April 16, 2021

Subject: Request for Modification of the Phased Section 404 Individual Permit and Section 401 Individual Water Quality Certification for the construction of the Triangle Expressway Southeast Extension from NC-55 Bypass in Apex to I-40, Wake and Johnston Counties. TIP Nos. R-2721, R-2828, and R-2829. Debit \$570 from WBS 376731.TA1.

This letter is a request for a modification to Site 44 on the R-2828 section of the Complete 540 project. Included in this package are updated permit drawings for Site 44 (Permit Sheets 1, 97, and 98 of 171), updated permit summary sheets 166 through 171 of 171, and updated roadway plan sheet 2F-9.

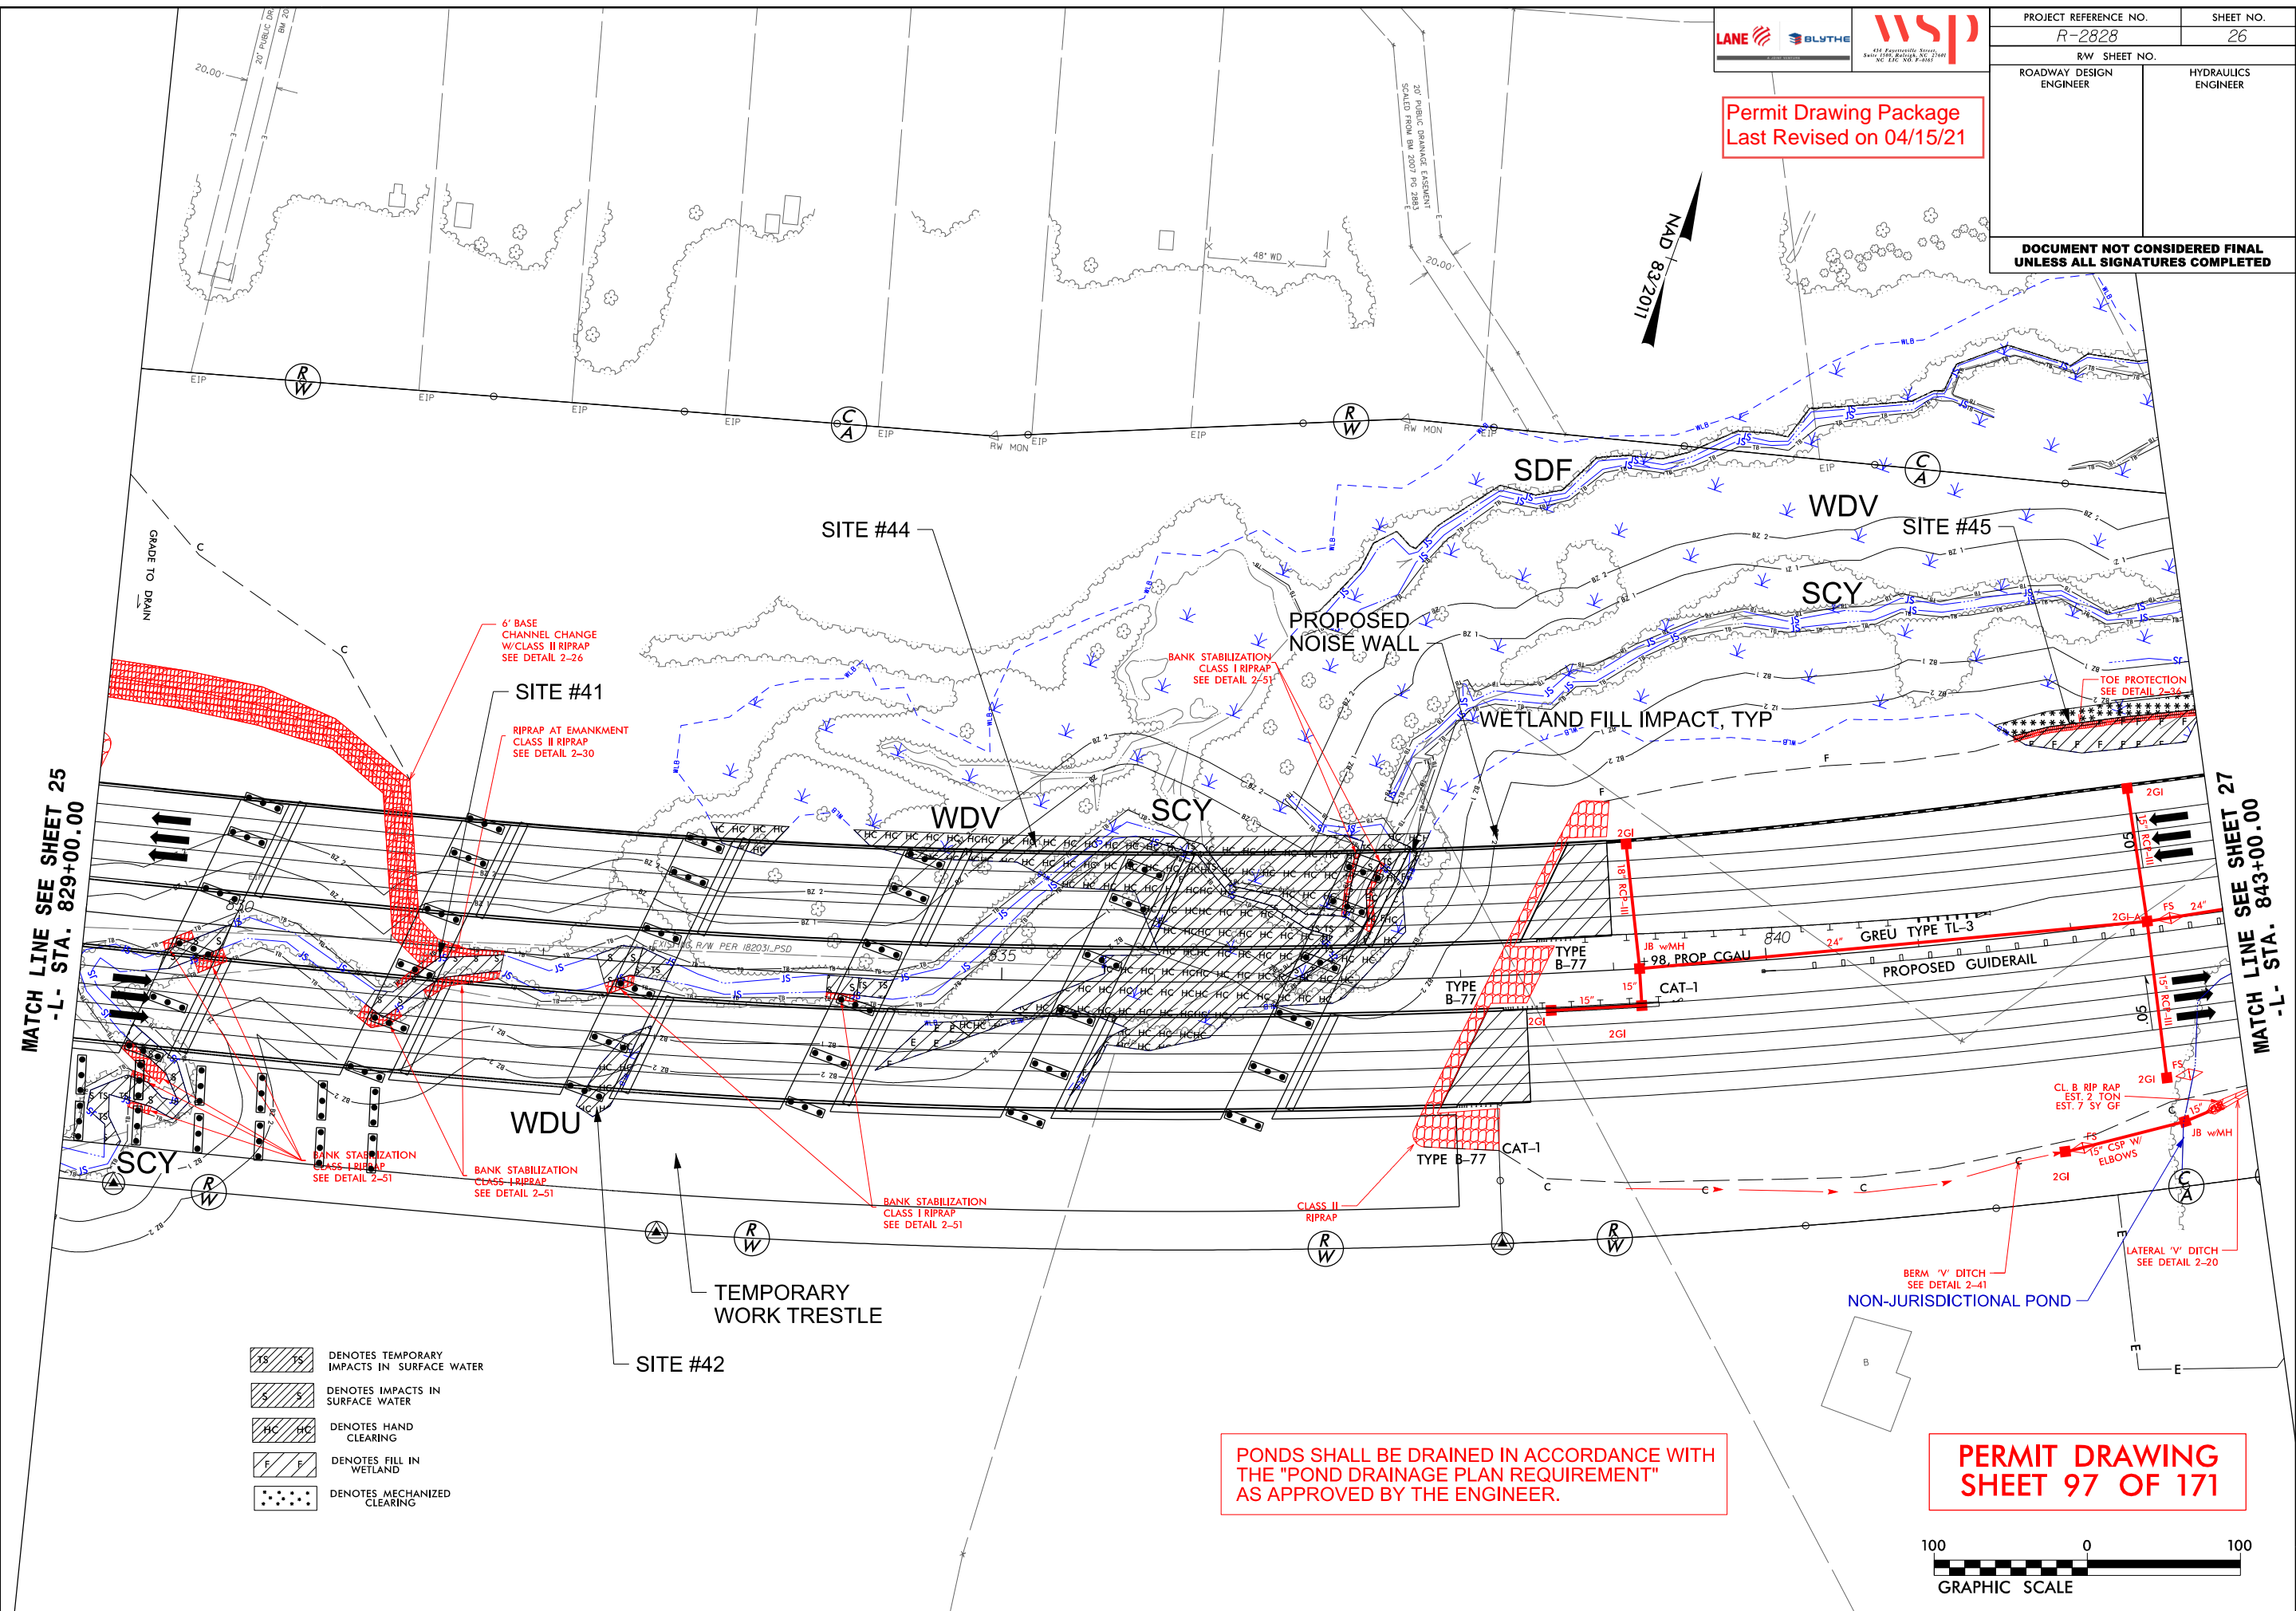
- Permit Site 44 (Permit Drawing 97 and 98 of 171, Plan Sheet 26)
 - Limited area of hand clearing changed to excavation:
 - Increase of 0.02 acre of wetland excavation impact.
 - Decrease of 0.01 acre of wetland hand clearing impact.

R/W SHEET NO.

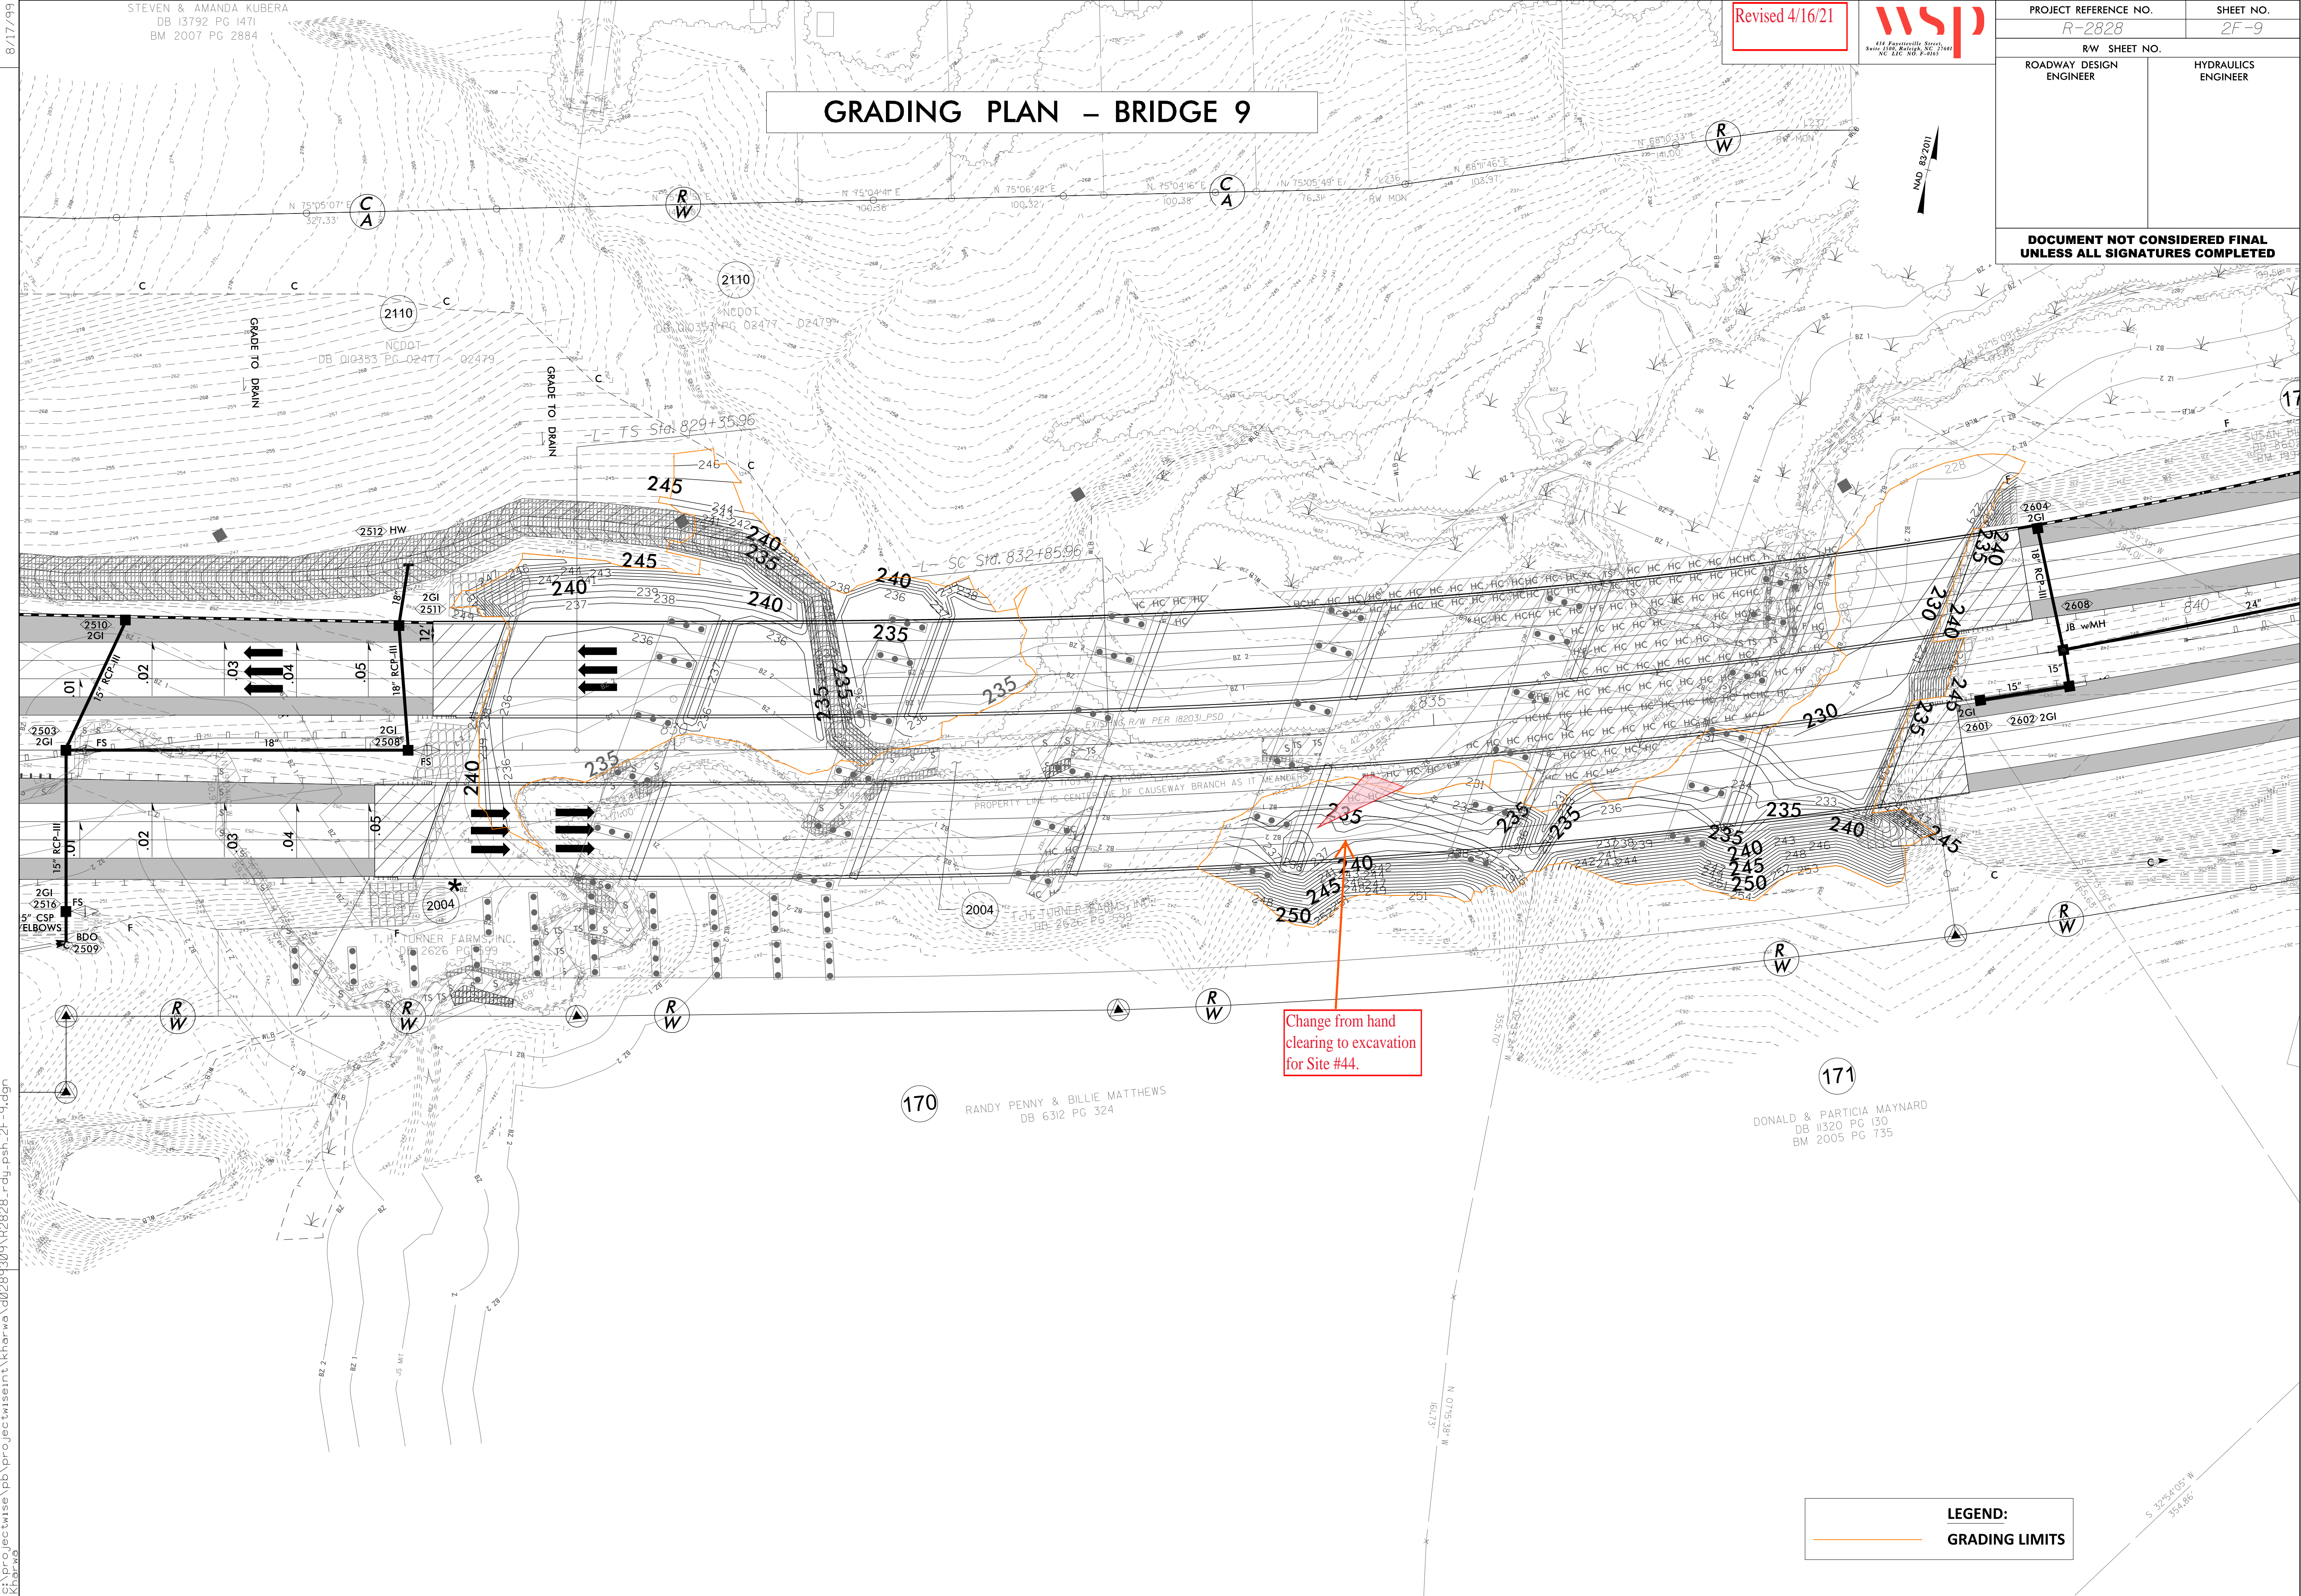
Construction of Bridge 9 is scheduled to begin shortly. During the field preparation to commence construction, it was noted that an area that is currently permitted as hand clearing is higher than the surrounding area and will actually need to be slightly excavated and graded to allow the required clearance under the bridge. The proposed changes to Site 44 are described below:

The reason for the difference in excavation to hand clearing impacts is due to rounding. Hand clearing at Site 44 was originally 0.55 acre (rounded from 0.551). The excavation is 0.0154 acre (which rounds to 0.02) and the new hand clearing is 0.5356 acre (which rounds to 0.54); thus the two values don't match.
